**M1 Pacific Motorway extension to Raymond Terrace (SSI 7319)
Advice on the Environmental Impact Statement (EIS)**

Thank you for the request for advice from Public Authority Consultation (PAE-24749572), requesting the review by the NSW Environment Protection Authority (EPA) of the Environmental Impact Statement (EIS) for the proposed M1 Pacific Motorway extension to Raymond Terrace (Application SSI-7319).

ATTACHMENT A: EPA COMMENT ON EIS FOR M1 PACIFIC MOTORWAY EXTENSION TO RAYMOND TERRACE (SSI 7319)

Location: L13 - 11 Cahill Close, Black Hill,

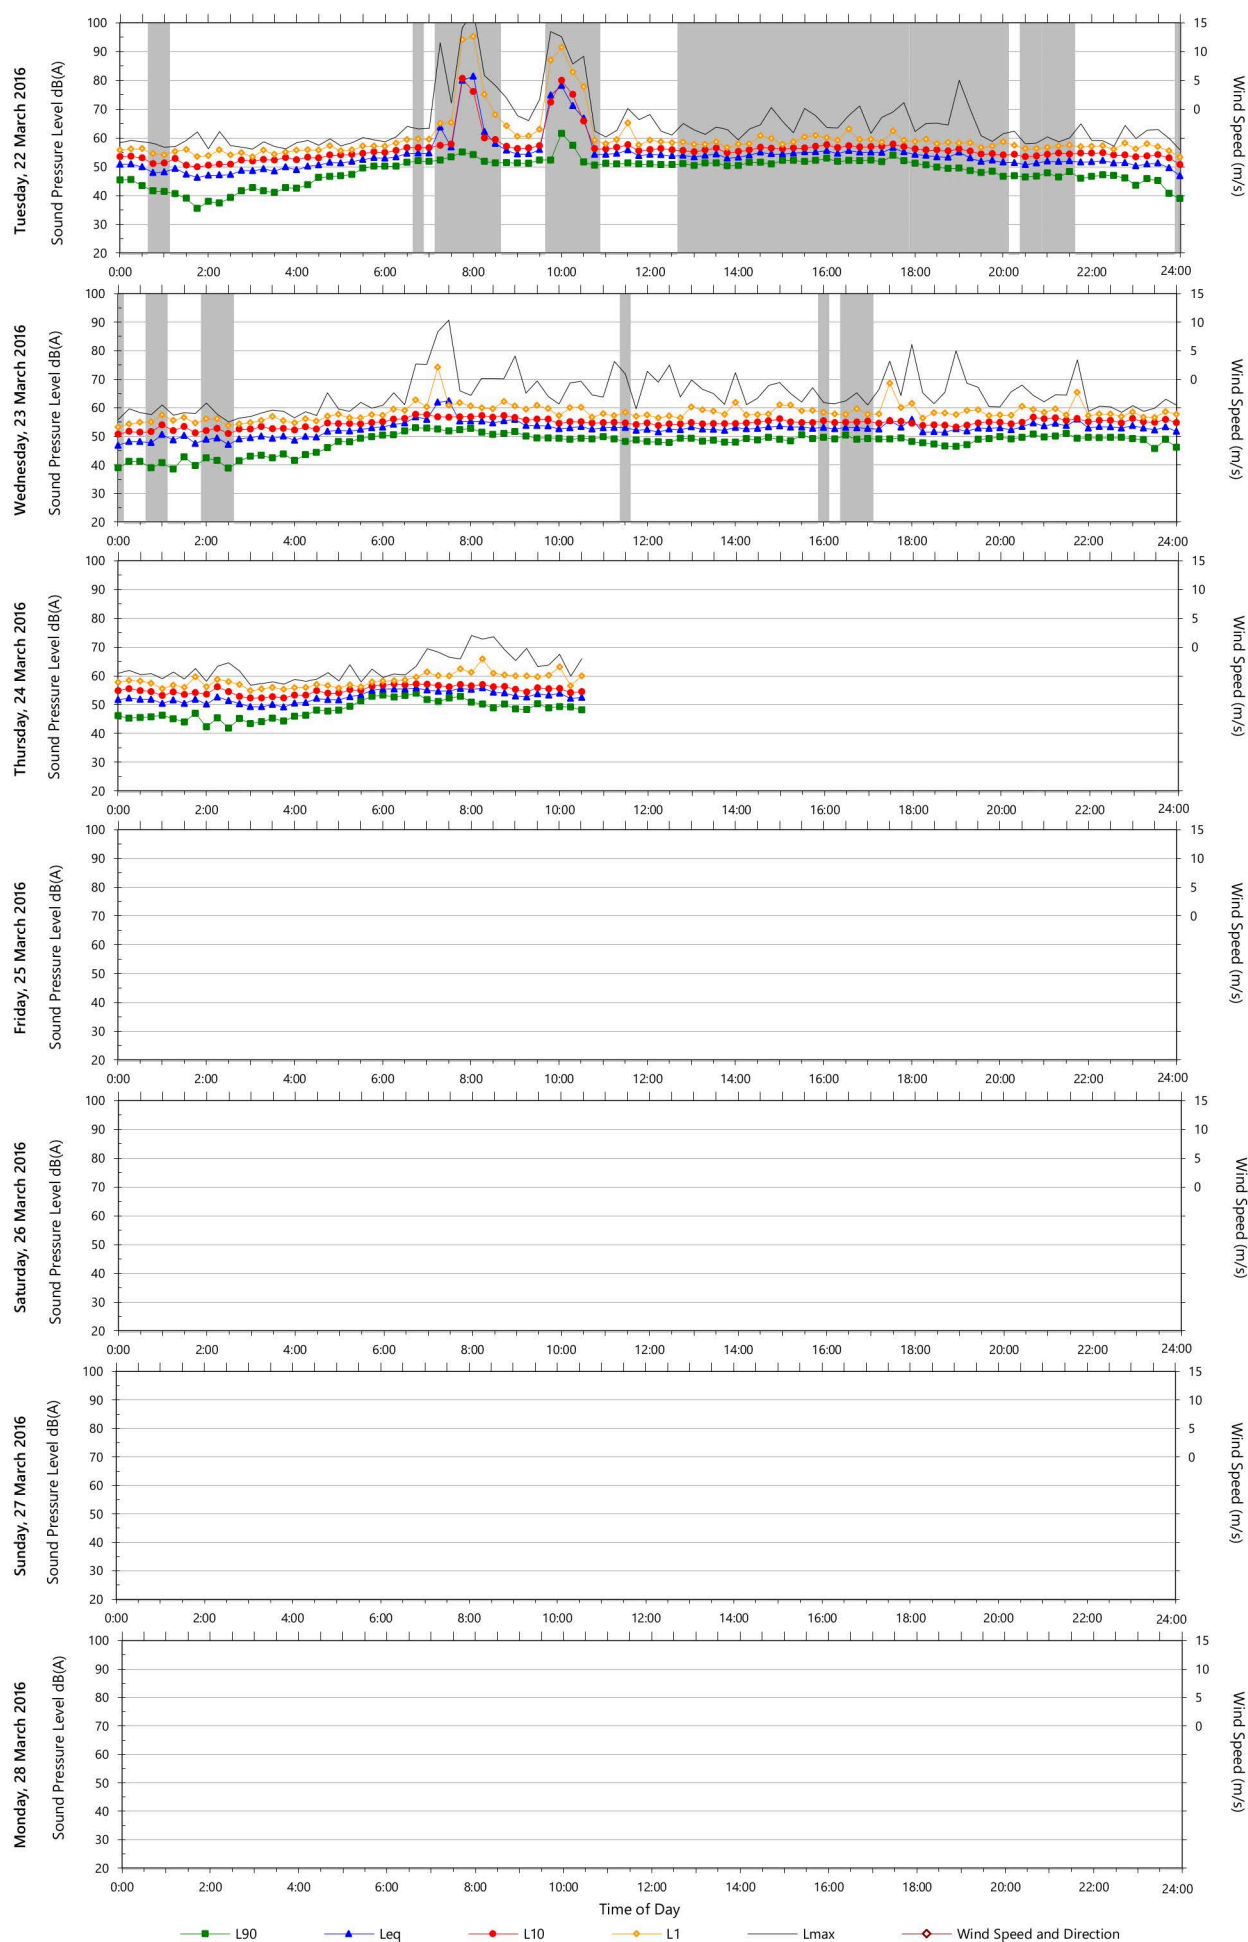
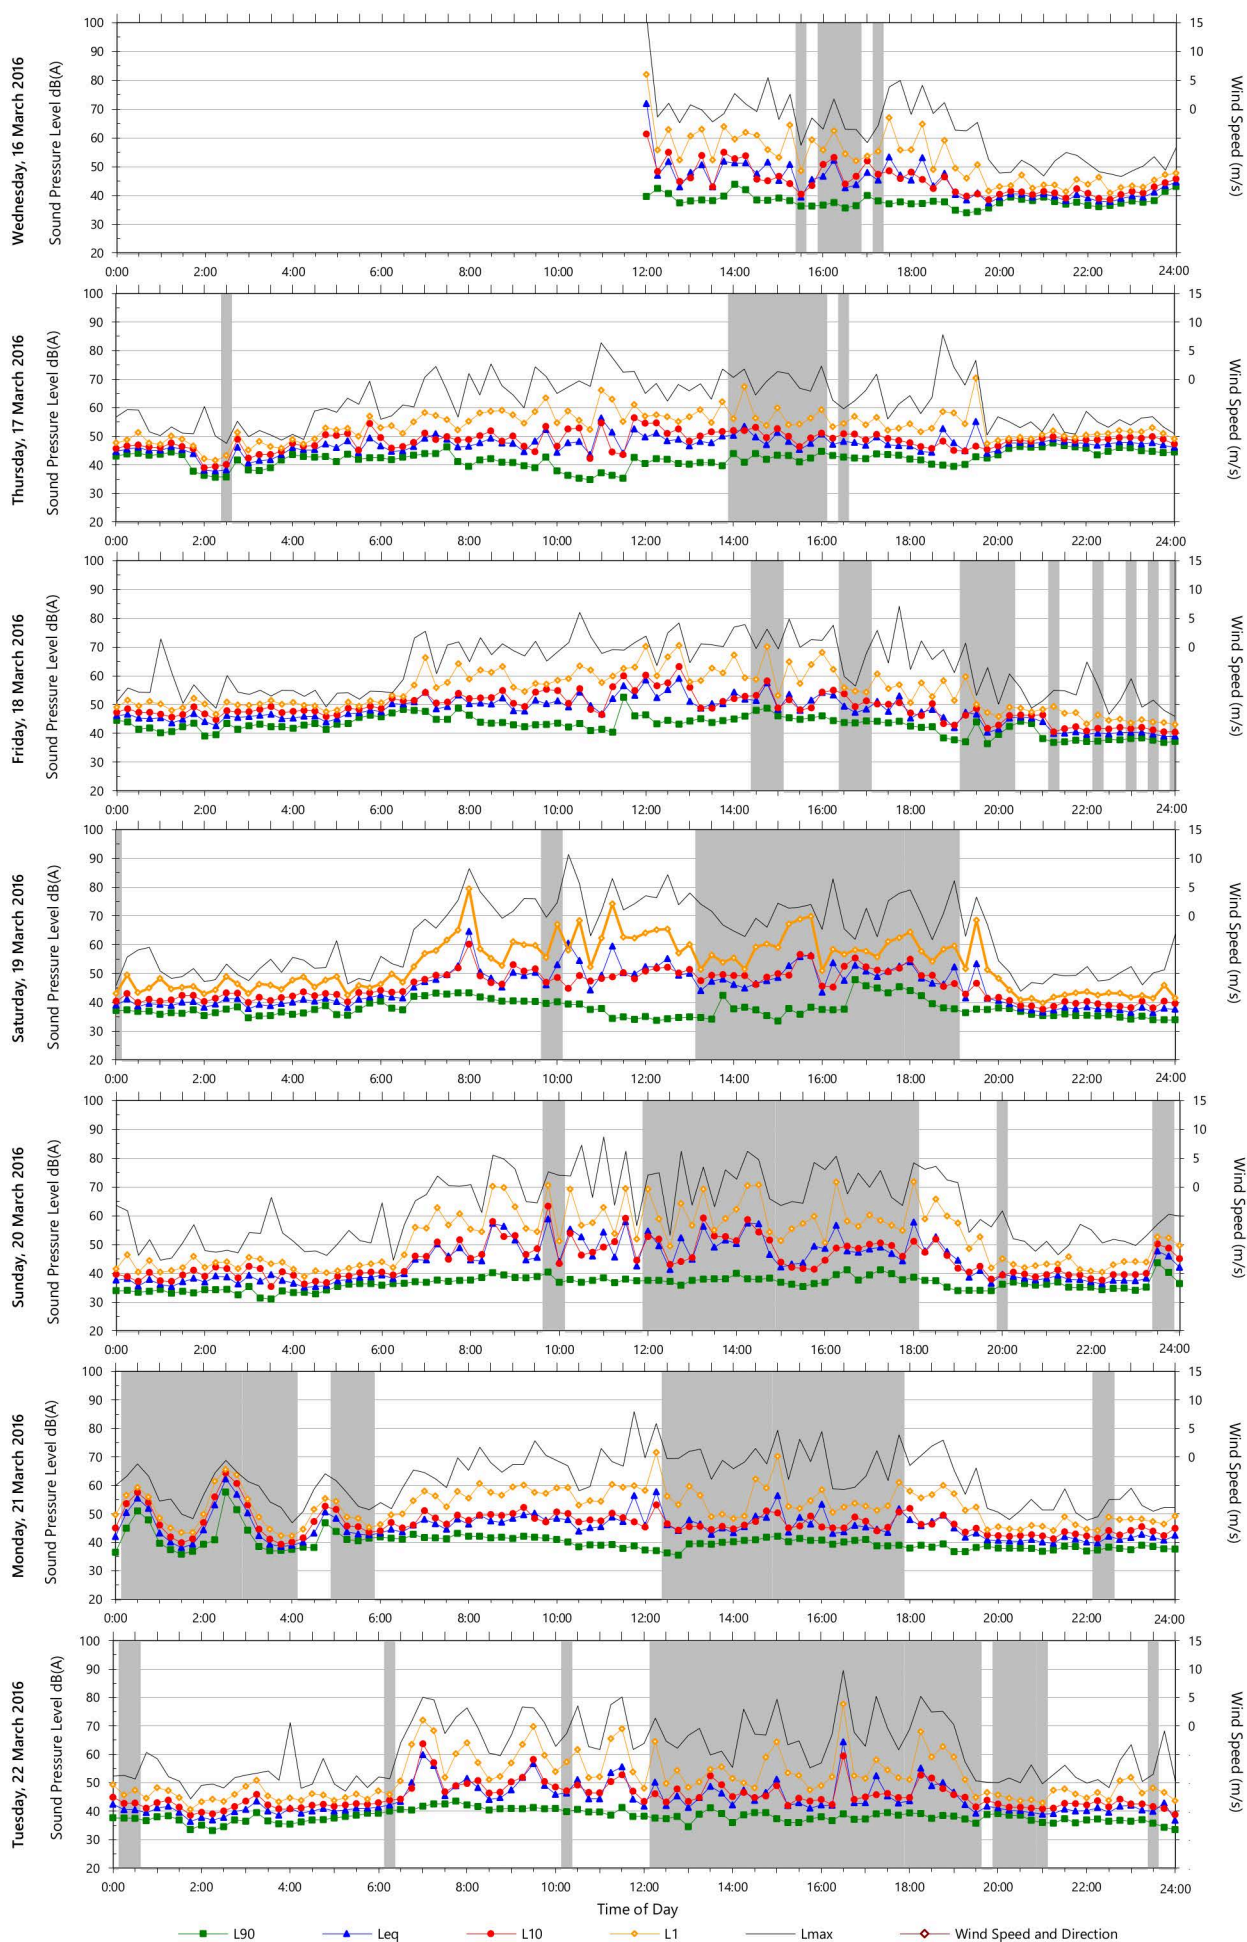
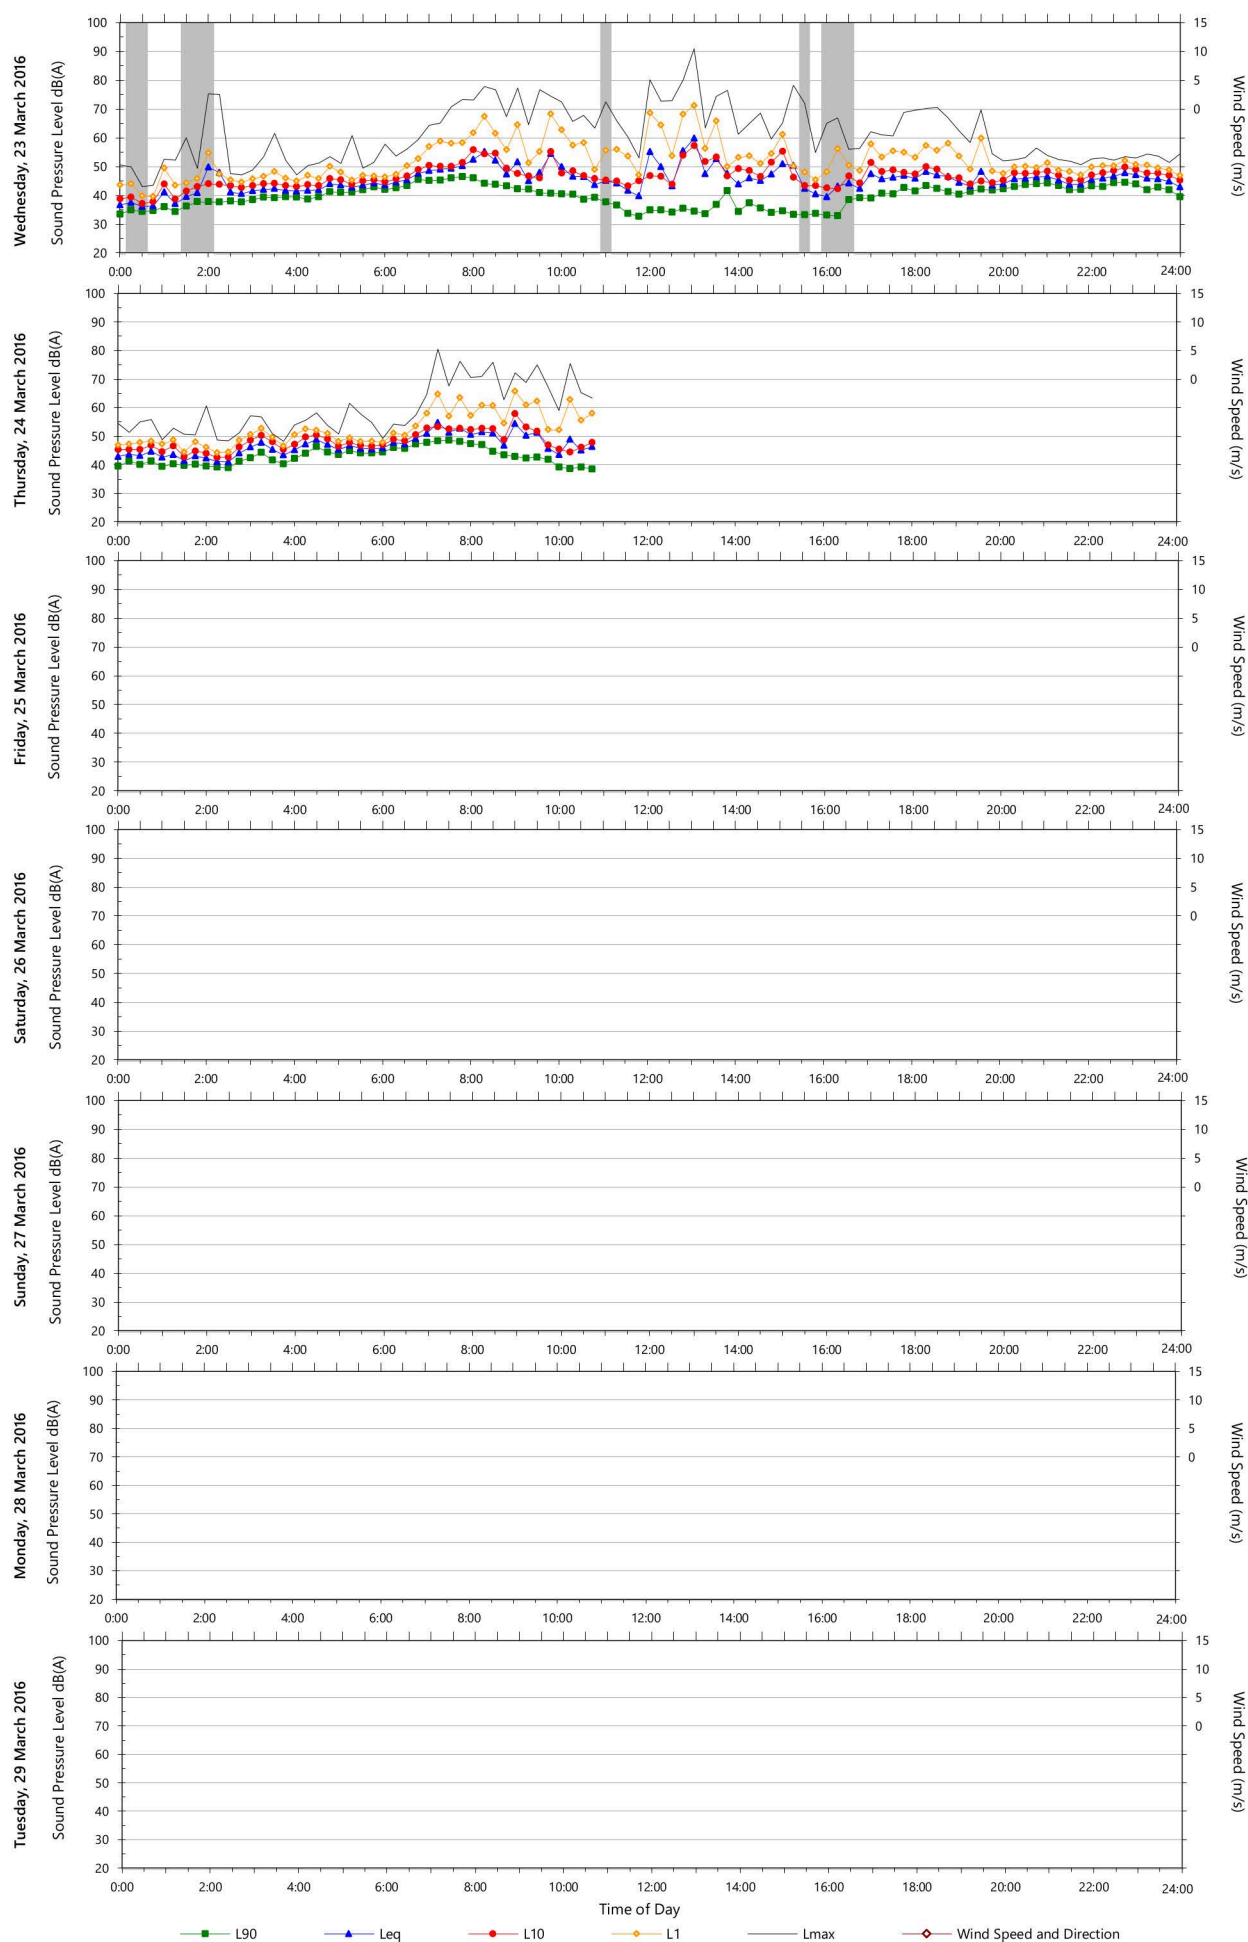
A review of the noise monitoring graphs in NIA Appendix B.2 indicates that further justification for the adequacy of noise monitoring presented or additional information is required.

A significant amount of data appears to have been excluded due to either inclement weather or extraneous noise. The EPA is concerned that the extent of data excluded means that it may not be representative of long term background noise levels, and therefore its suitability to be used to establish reliable noise management levels could be called into question.

Locations L01 to L014 (inclusive) appear to have no more than 5 and in some cases less than 3 valid periods out of the total monitoring duration. Locations L15 to L20 appear to be less affected, however there it is still not clear if sufficient valid data has been presented.

Fact Sheets A and B in the Noise Policy for Industry (NPfI) set out the EPA's requirements for establishing background noise levels. Due to the amount of data excluded, it is currently not clear if these requirements have been satisfied nor if sufficient valid data has been presented in order to establish representative background noise levels.

Noise monitoring was also conducted in 2016 for the purposes of measuring road traffic noise. Due to the amount of data excluded at Locations L13 to L20, further justification is needed that the remaining data, after invalid samples were excluded, provides sufficient amount of data to enable a representative calculation of the traffic noise descriptors.

The proponent reviews the noise monitoring data in the NIA in the context of the monitoring requirements set out in the NPfI and for each location and either:

- Provide a justification and demonstrate that the requirements of the NPfl have been fulfilled; or
- Provide additional data that fulfills the monitoring requirements in the NPfl.

The EPA also recommends that the proponent either:

- Provides justification and demonstrate that the data presented for road traffic noise descriptors is sufficient to be representative; or
- Provides additional valid data.
